Your Ref: OWPC2607
Our Ref: AB/130/13/ 16-12-2013
Please ask for:
Mrs A Gardner

Change of use and extension to create 3no. self contained apartments and 1no. maisonette. This application affects the character and appearance of Arundel Conservation Area
Arden Guest House 4 Queens Lane Arundel

Job Title	Arden Guest House		
Client	Mr & Mrs Meathrel		
Drawing Name	Proposed Elevations		
Drawing Status	Planning		
Drawn by	DF	Date	Dec 13
Checked by		Date	
Drawing Scale	1:100 at A2		
Drawing No	Status	Revision	
13519/	08

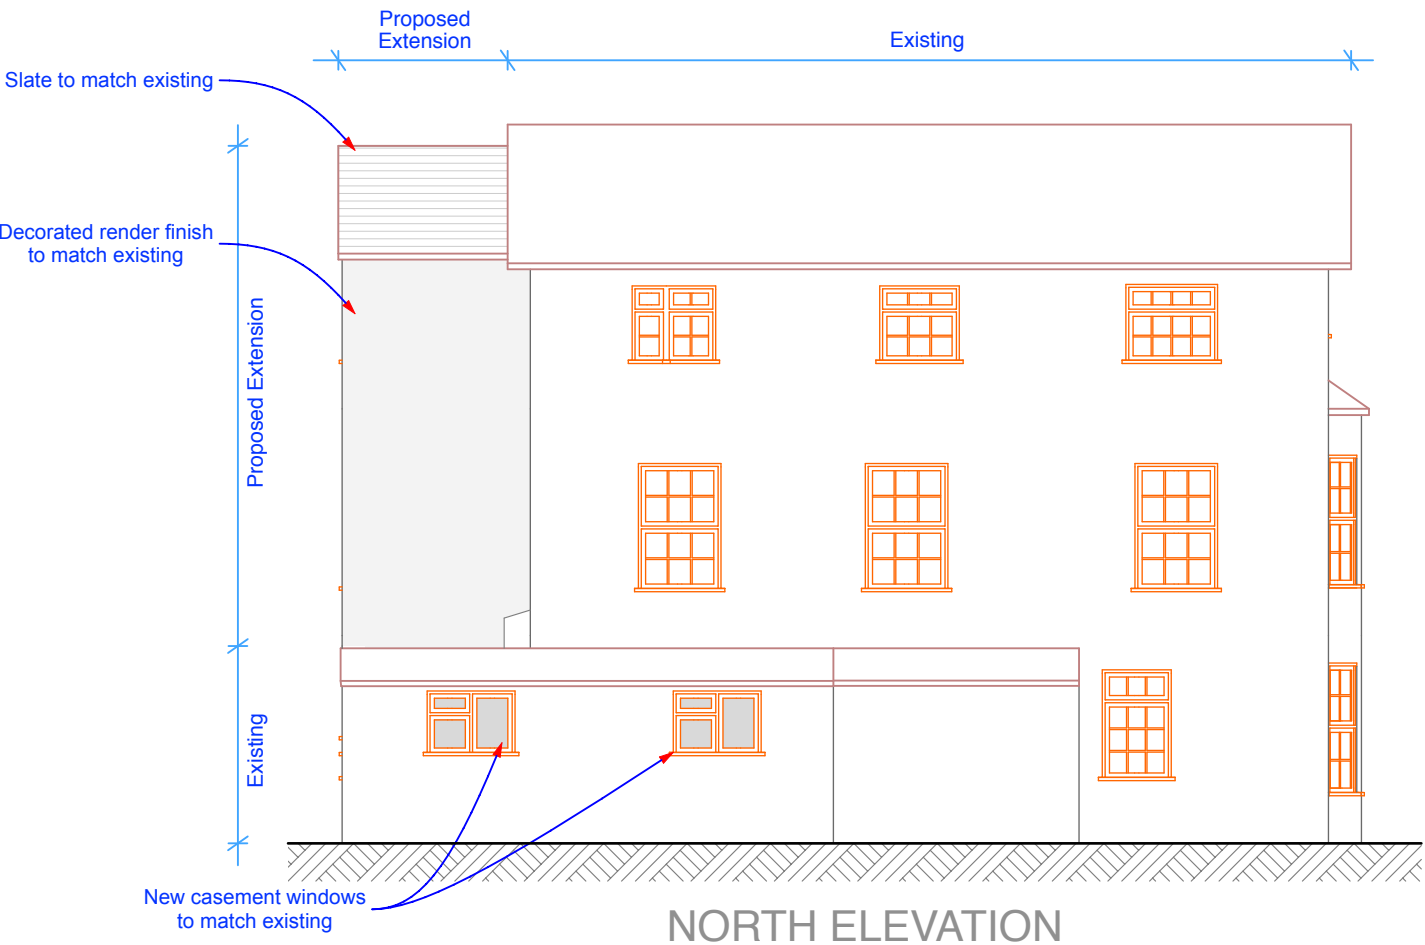
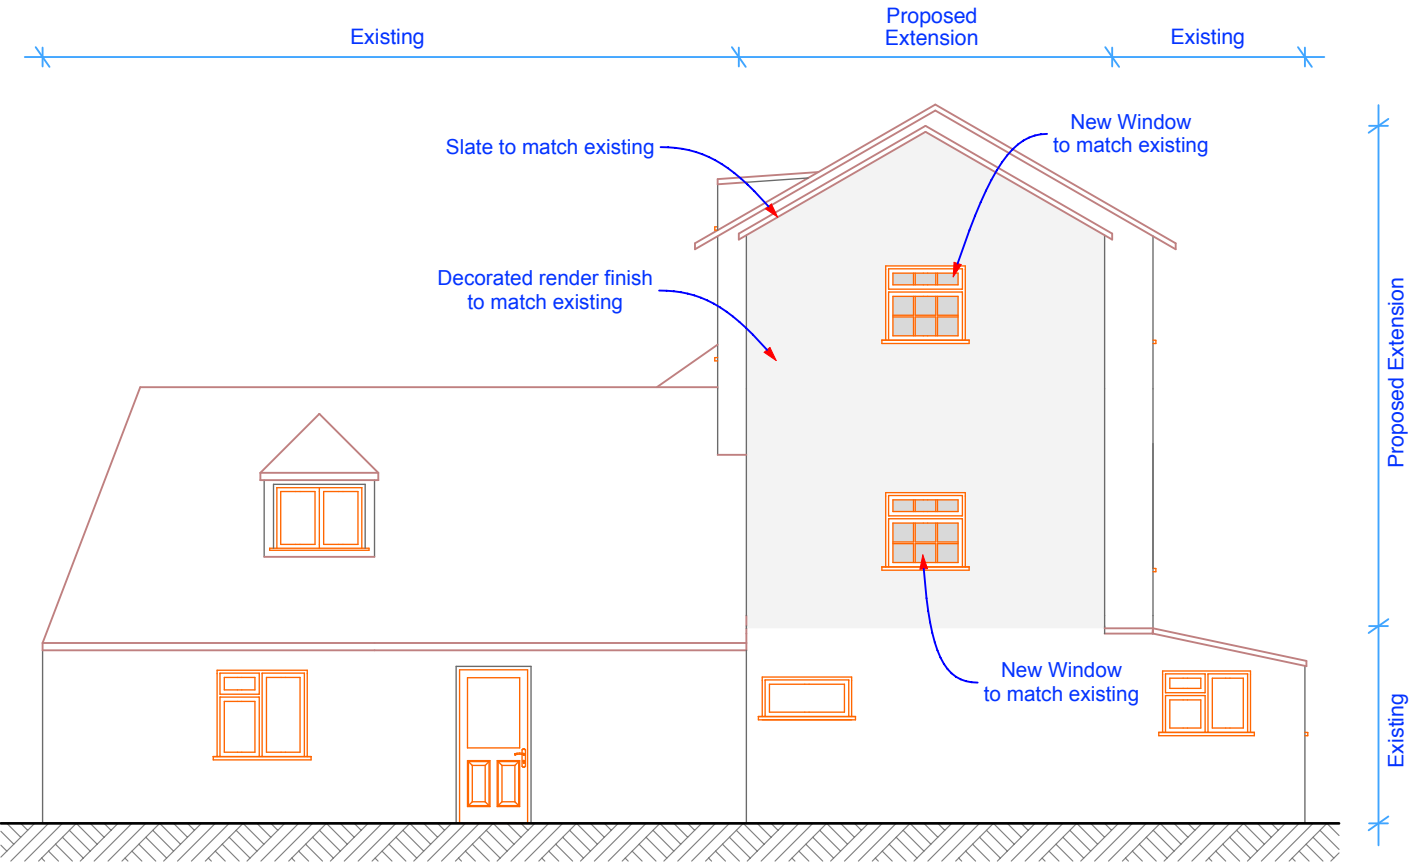
Our property directly faces the East Elevation of the proposed application with some of the replacement windows facing directly into our dwelling.

My observations on the actual application draws your attention to Section 9 headed Materials. On the ground floor roofs on the existing North Elevation there is bitumen felt sheeting on the low pitched roof above the ground floor kitchen. In addition there is PVC corrugated sheeting adjacent and above the existing bathroom. In both cases there is no mention of these in the application and therefore there is no provision to change these materials nor raise the roof pitch suitable for domestic dwellings.

My other constructive proposal would be to insist that the new staircase windows, on the East Elevation, be installed with privacy glass, available in double glazing, similar to the Textured/Decorative glass produced by Pilkington Glass.
